June 24, 2008

RE: Anderson Avenue, Little Diamond Island – 105 J017 – IR-2 – adding bathroom & kitchen area to outbuilding – permit #08-0651

Lot 105-J-018 Anderson Ave. Little Diamond Island  
Work Description: Add Bathroom and Serving Area

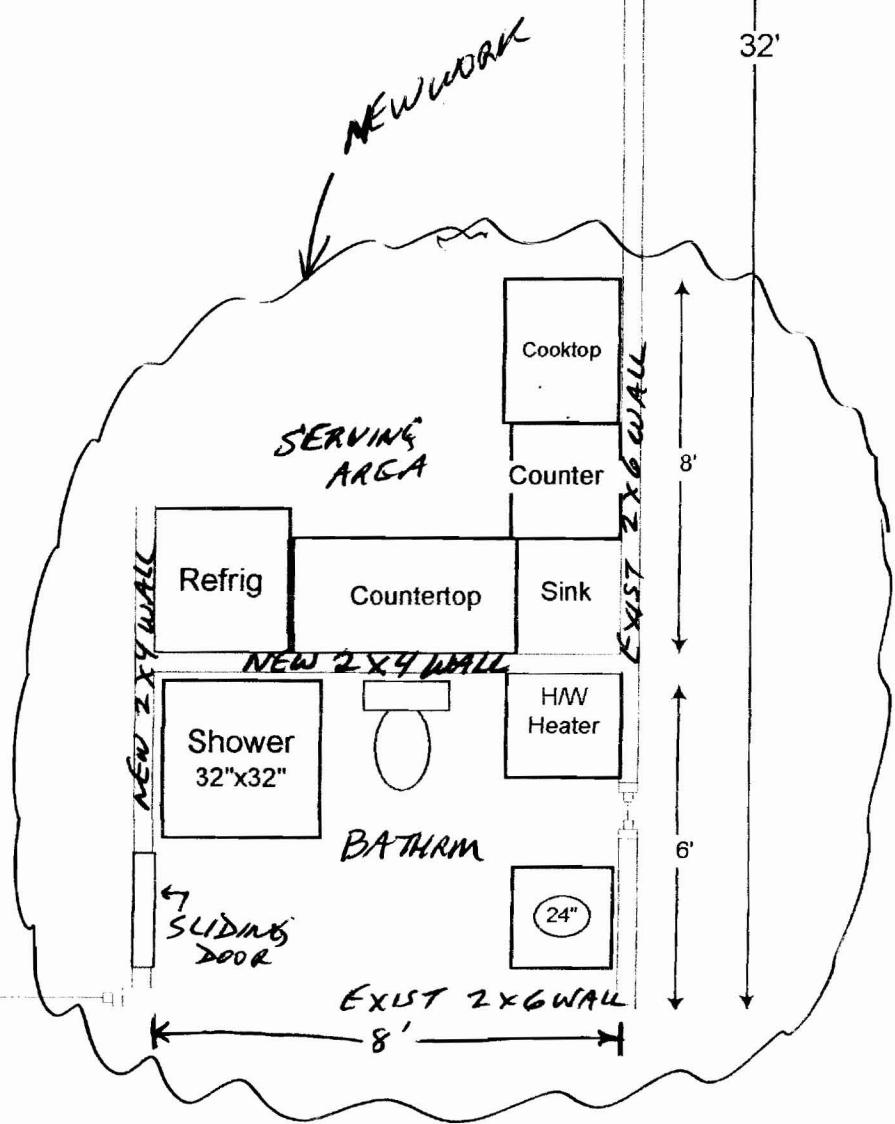
In addition, the serving area that you proposed to add to the building constitutes a kitchen. Under the land use ordinance, the addition of a kitchen and bathroom to the building creates a dwelling unit. The IR-2 zone only allows for single-family dwellings. Under section 14-145.9(a)(1) of the ordinance, you can add an accessory dwelling unit within the principal single-family dwelling providing that you can meet the criteria listed under this section. The second condition listed under this section states that your lot must be 30,000 square feet. Your lot size is 26,388 square feet, so you do not meet the criteria for lot size. This is a conditional use, so if you wanted to pursue it, you would have to appeal to the Zoning Board of Appeals. Since you do not meet all the criteria, you would have to make a separate appeal first for a variance in the required lot size for an accessory dwelling unit.

PLOT PLAN  
1" = 50'

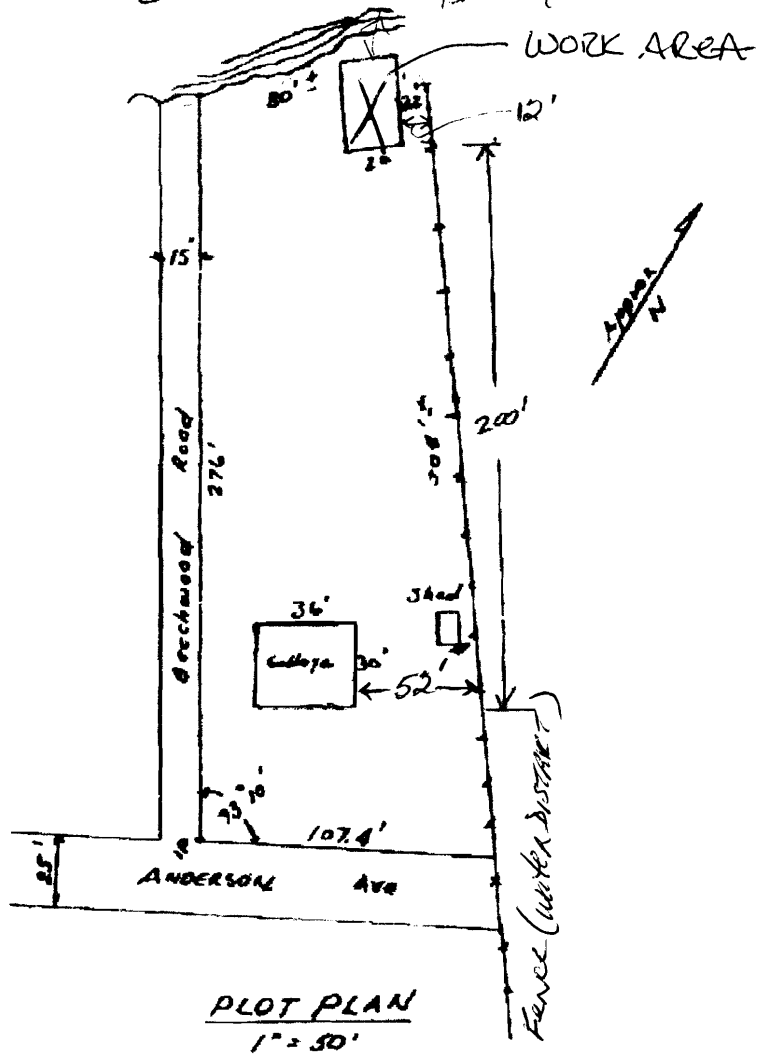
According to our records, the permit (#00563) to build the outbuilding was issued on May 9, 1986. The use for the outbuilding was given as a “1 story building to be used for storage of fishing gear.” Your property is located in the Shoreland Zone. Your plot plan gives the setback to the shed from the high water mark as ten feet. Section 14-449 of the ordinance states that all principal and accessory structures must be set back at least seventy-five feet from the normal high water line. Since the outbuilding was built before this section of the ordinance went into effect, the use of the building as storage for fishing gear is legally nonconforming. Since the building is legally nonconforming, the use cannot be changed to add a bathroom and kitchen area. The use must remain as a building for the storage of fishing gear.
